Recommendation Report for Listed Building Consent for Alterations, Extension or Demolition

REF NO: Y/76/14/L

LOCATION: Berricourt
Main Road
Yapton

PROPOSAL: Application for listed building consent for 1 No proposed fence

DRAWING	SCALE
Proposed Fencing Plan	Values

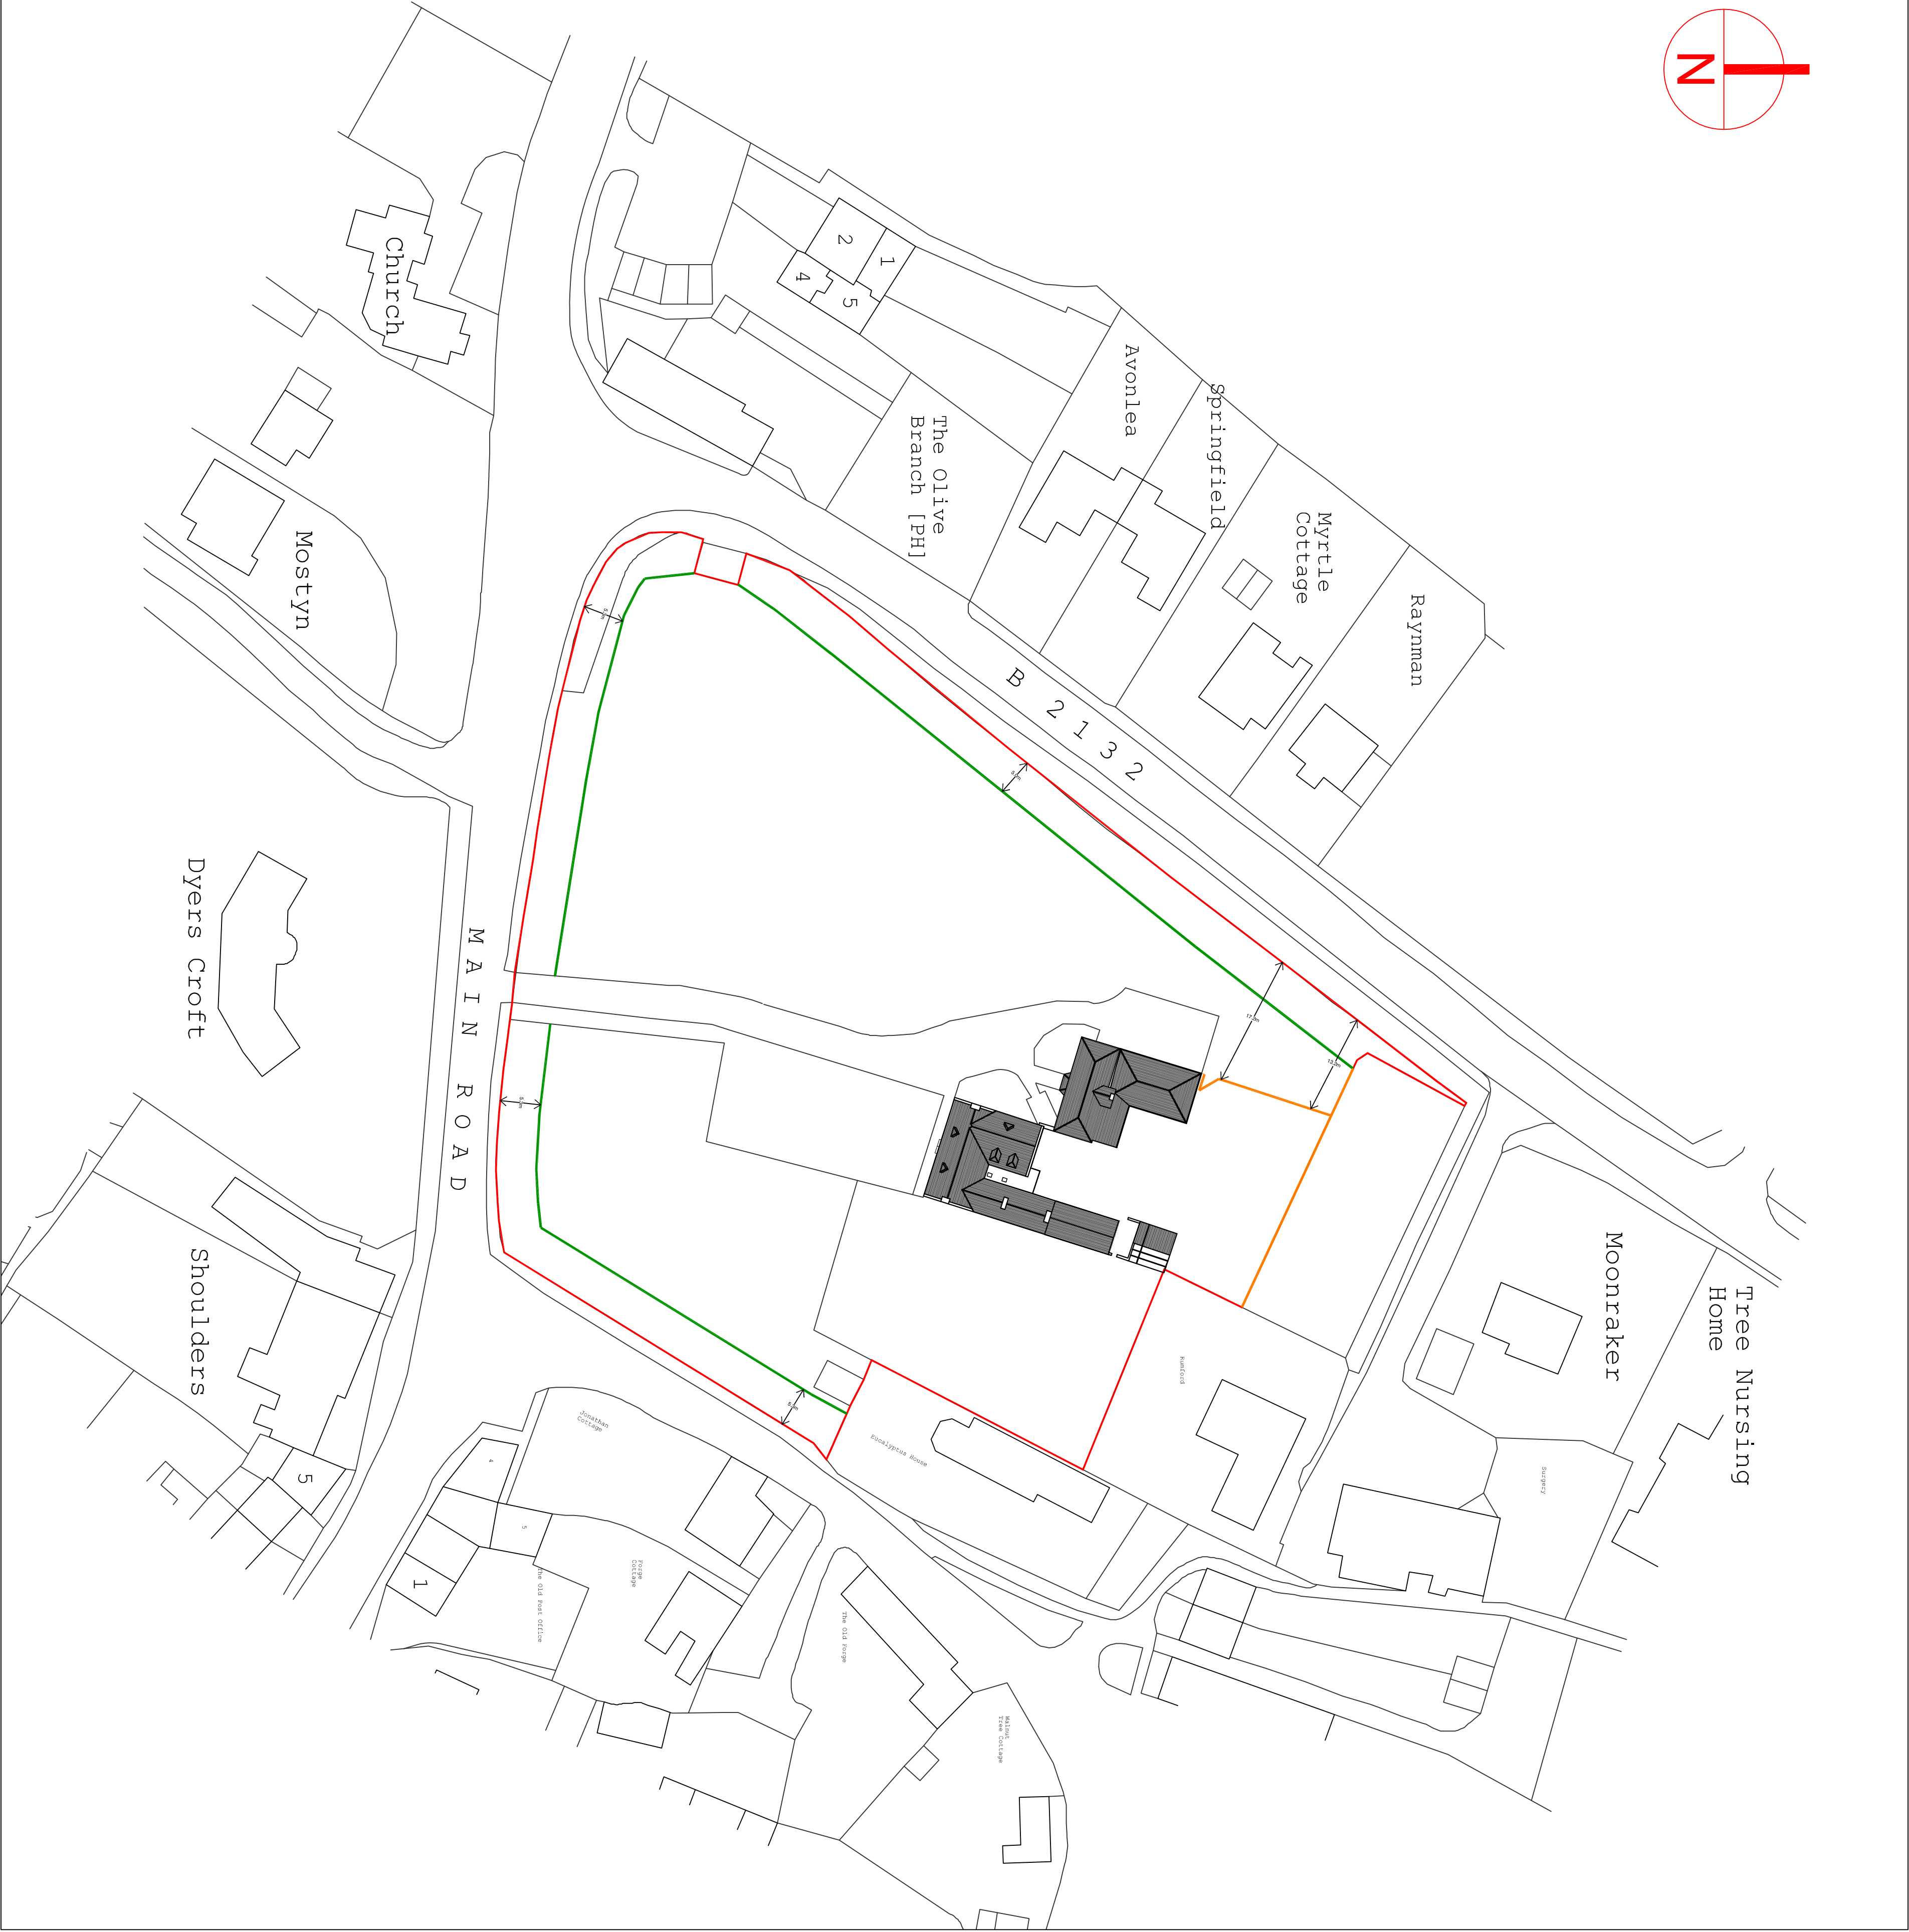
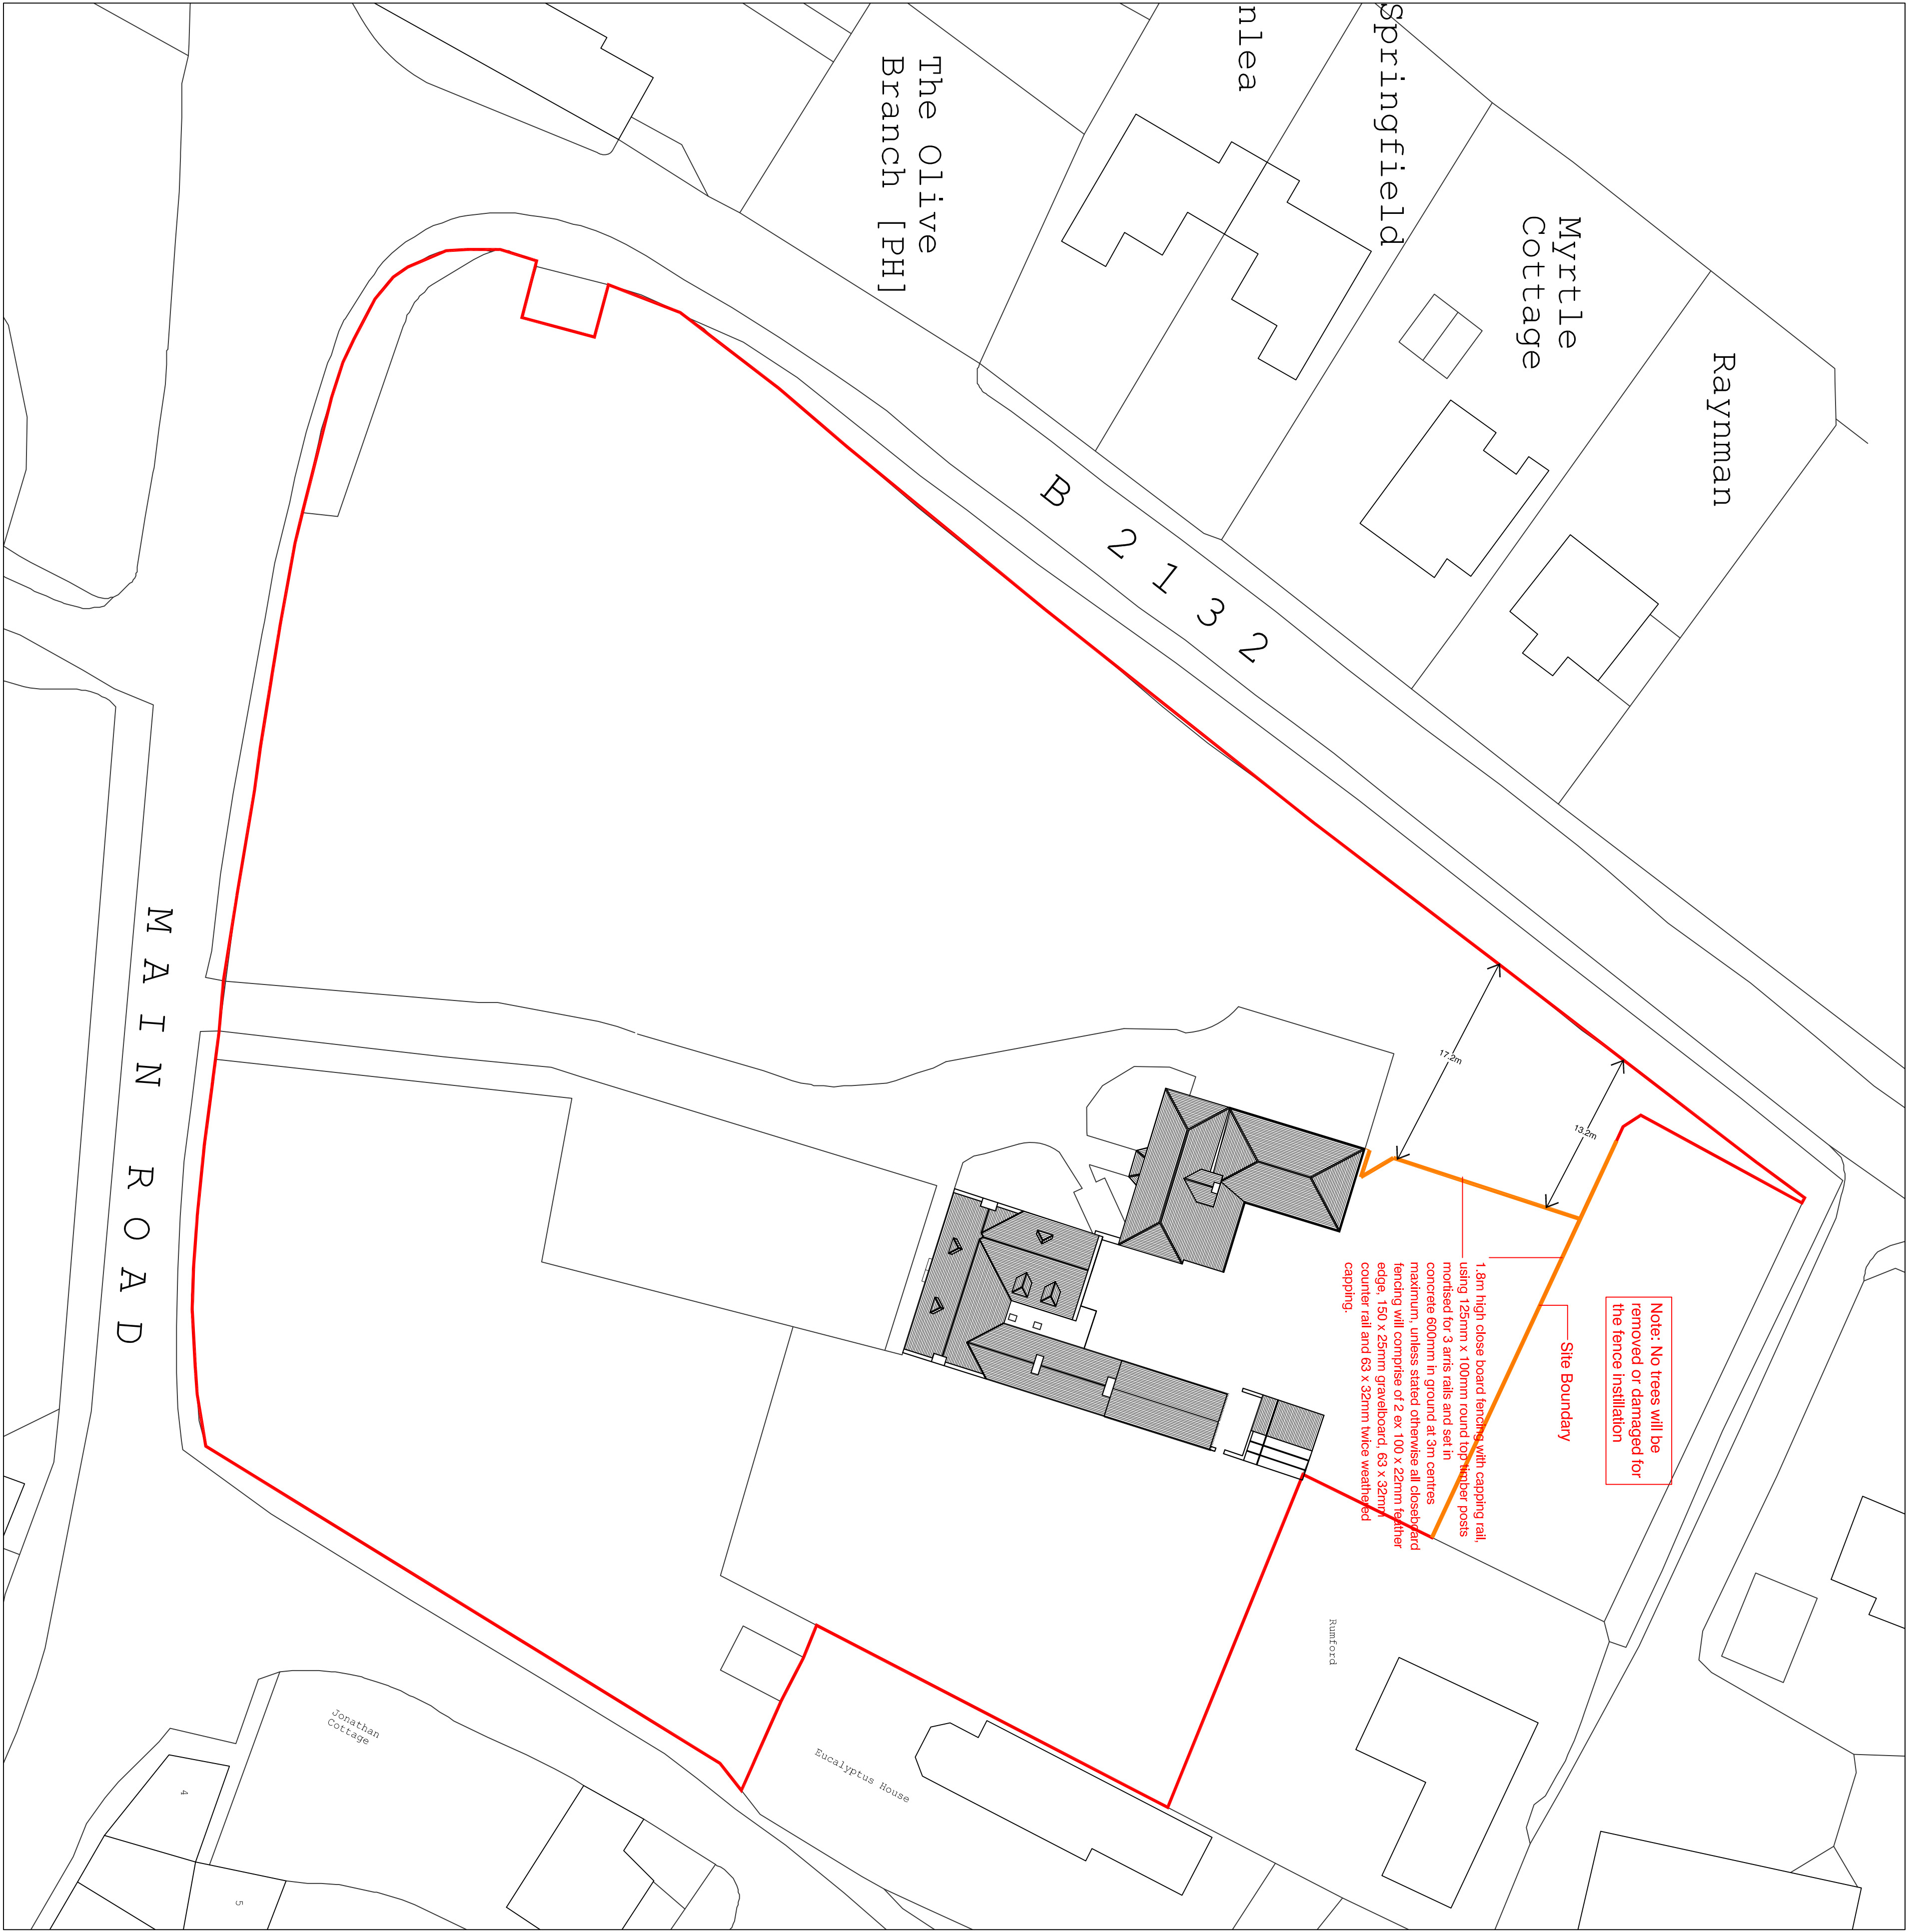
Yapton Parish Council - "The Planning Committee have no objection to the close boarded fence one. We do however object to fence two, a Protek 1000 mesh panel fence which we consider to be totally inappropriate for this property located in Yapton's southern Conservation Area. It will not complement the building or the grounds. The current boundary wall and hedging which has been a feature of the street scene at this location for many years is considered to form an adequate and appropriate boundary"

Historic Buildings Adviser - Initial comments stated: "It is unclear what the justification is for this level of fencing, given that two different types are being proposed. Of particular concern however, is the metal mesh fencing which is particularly inappropriate in this context and could harm the setting of the listed building. It is rather austere and is likely to affect the way the garden and house are experienced."

Subsequently clarified these with: "I am less concerned with the wooden fence as this should fade and will be partially screened. The mesh fence should be removed."

Noted. The applicant has amended the application to remove the mesh fence. Yapton

Comments noted. As noted above, the applicant has amended the application to remove the mesh fence.

- 2 The development hereby approved shall be carried out in accordance with the following approved plan: Proposed Fencing Plan Ref 12127/135 Revision B.
